From: Peter Cook [REDACTED]
Sent: 21 May 2015 15:05
To: Planning [REDACTED]
Subject: Homeville Planning Application - BN/18/15/HH

Ref: Homeville Planning Application - BN/18/15/HH

Development: Single storey rear extension & change in rear fenestration.

Location: Homeville - Lake Lane Barnham

LOCATION PLAN PLANNING APPLICATION

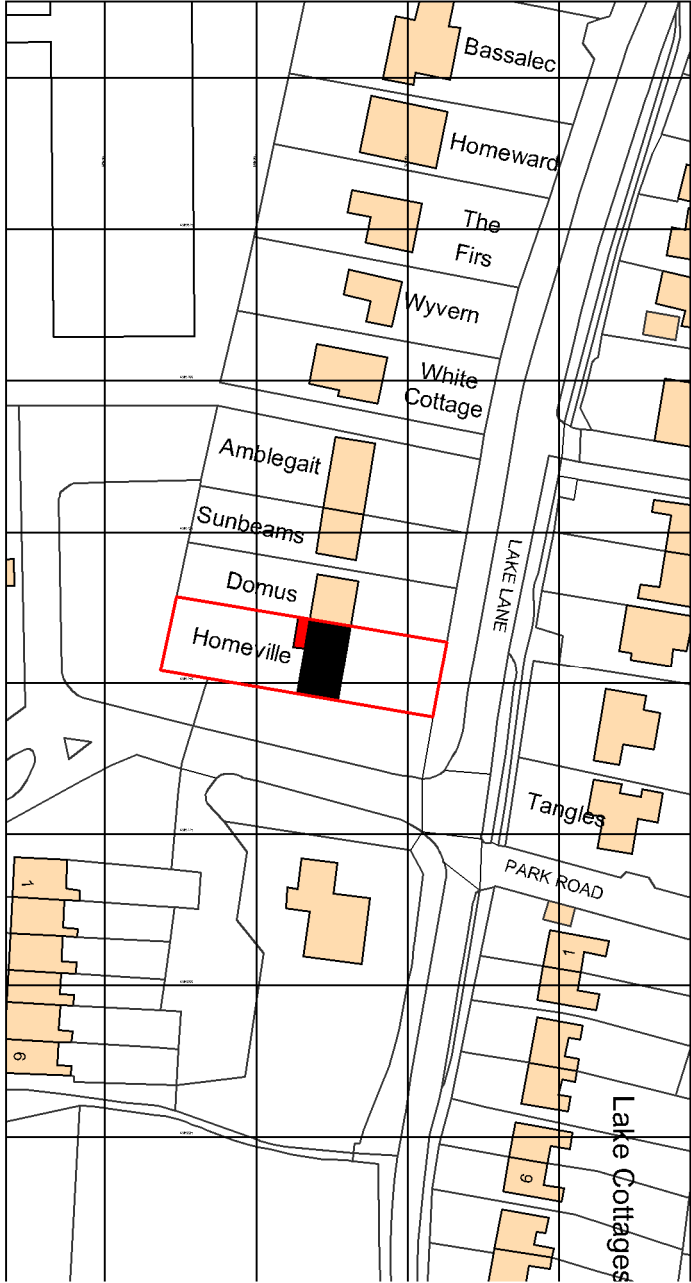
1. Block Plan –

- a) We have attached a Block plan drawing A2142PA2000 at a scale of 1:200 which will enable you to read the dimension
- b) We have indicated the dimension from the rear of the proposal to the rear site boundary.

EXISTING ELEVATIONS

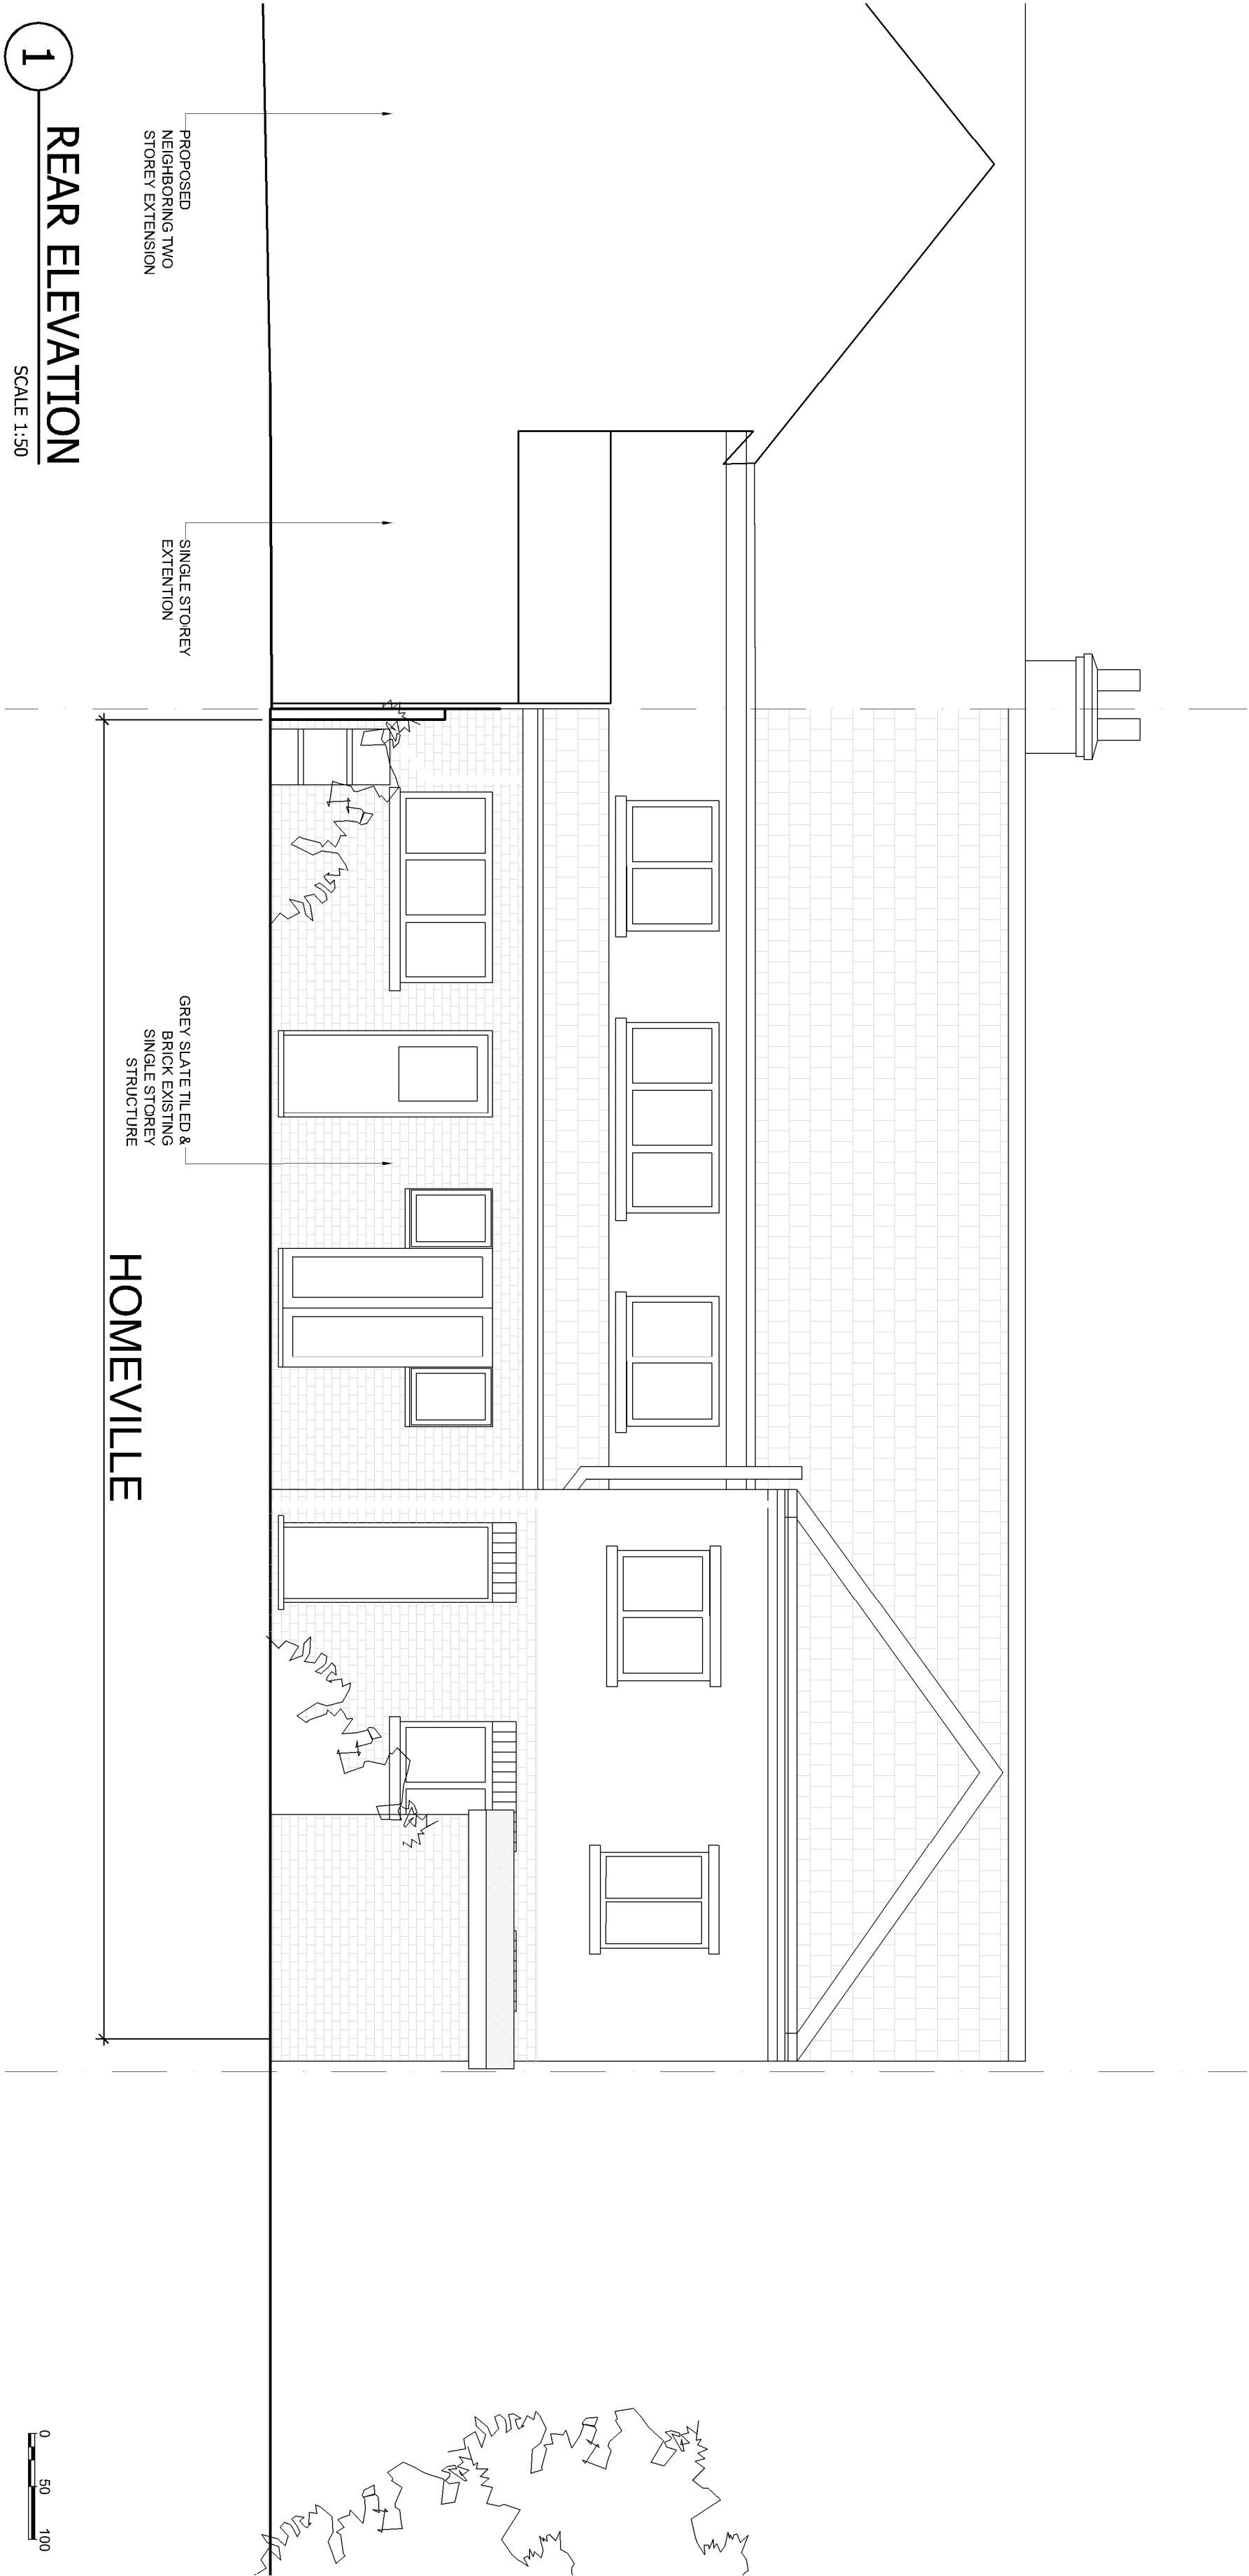
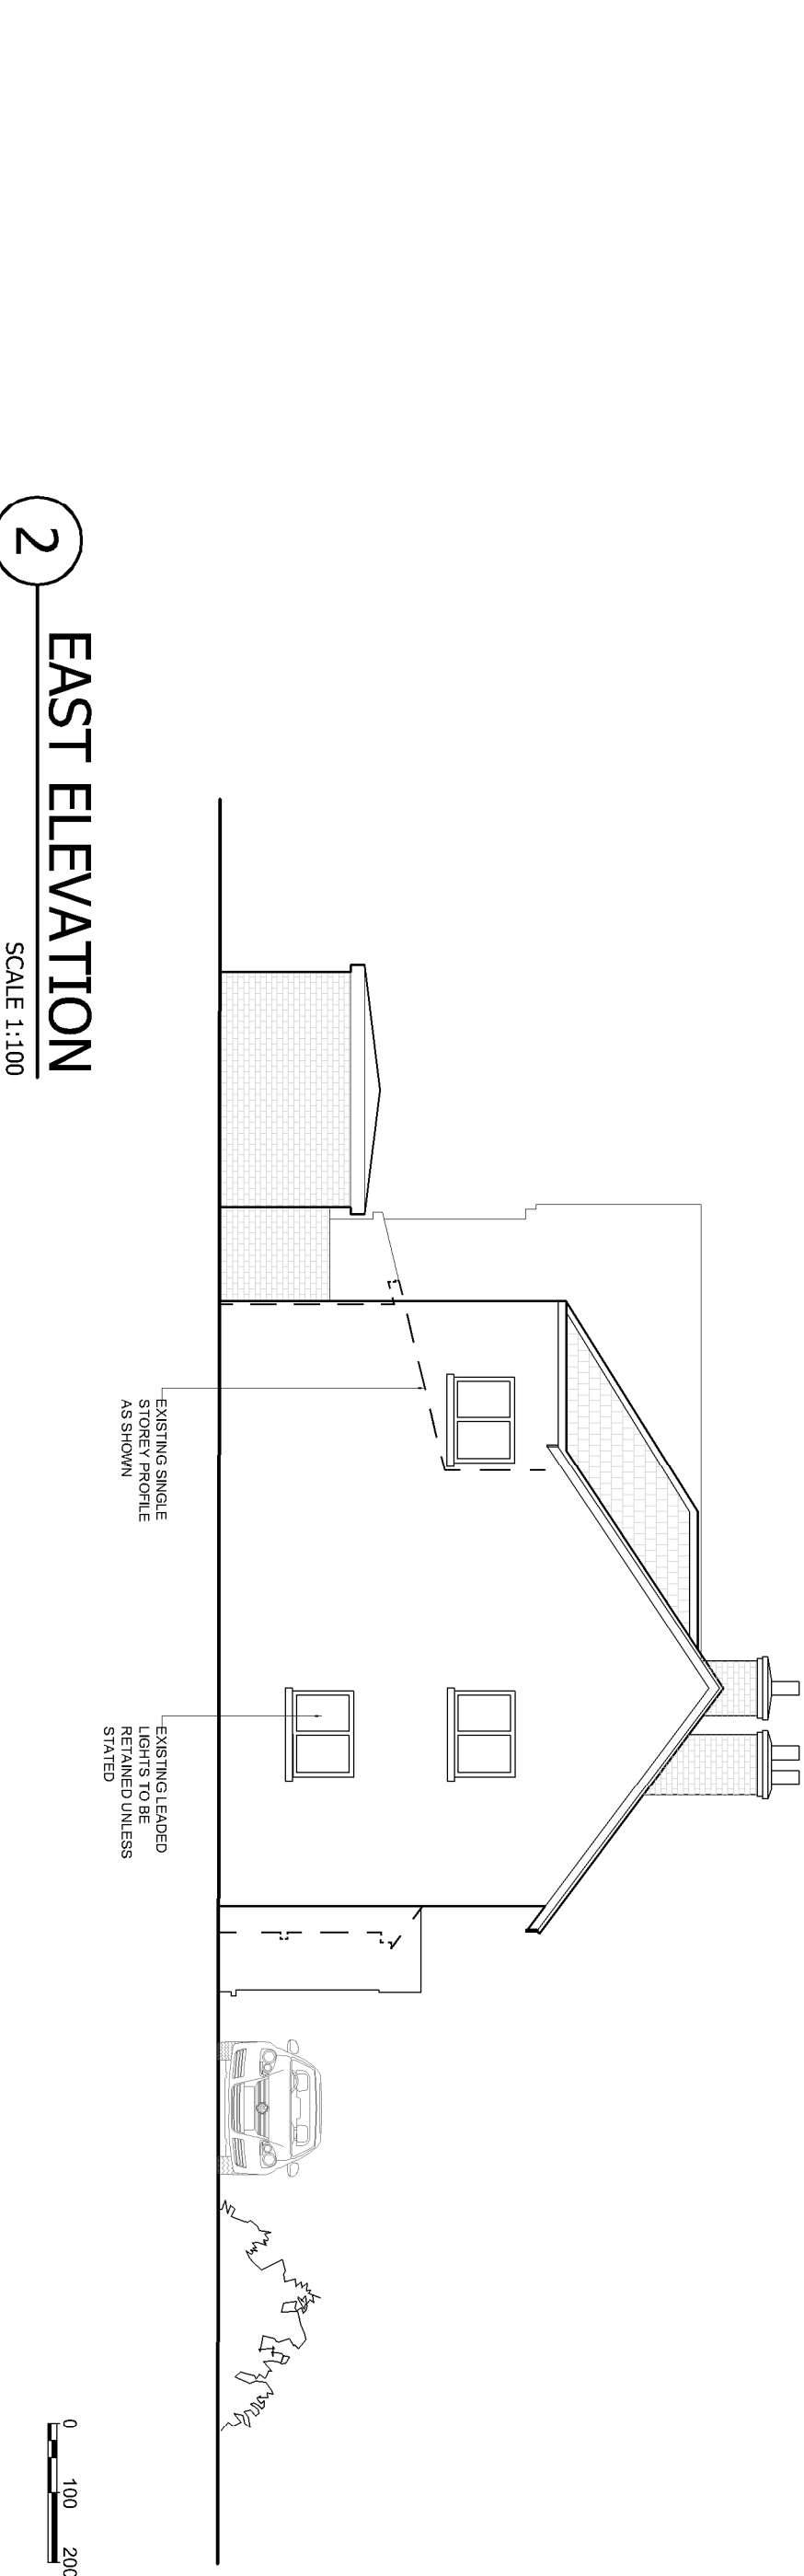
2. Elevations and Plan –

- a) The existing and proposed East Elevations have been updated to accord with the Ground Floor Plan. Please see the attached documents A2142EX3000_REVA, A2142PA3001_REVA, A2142PA2001_REVA
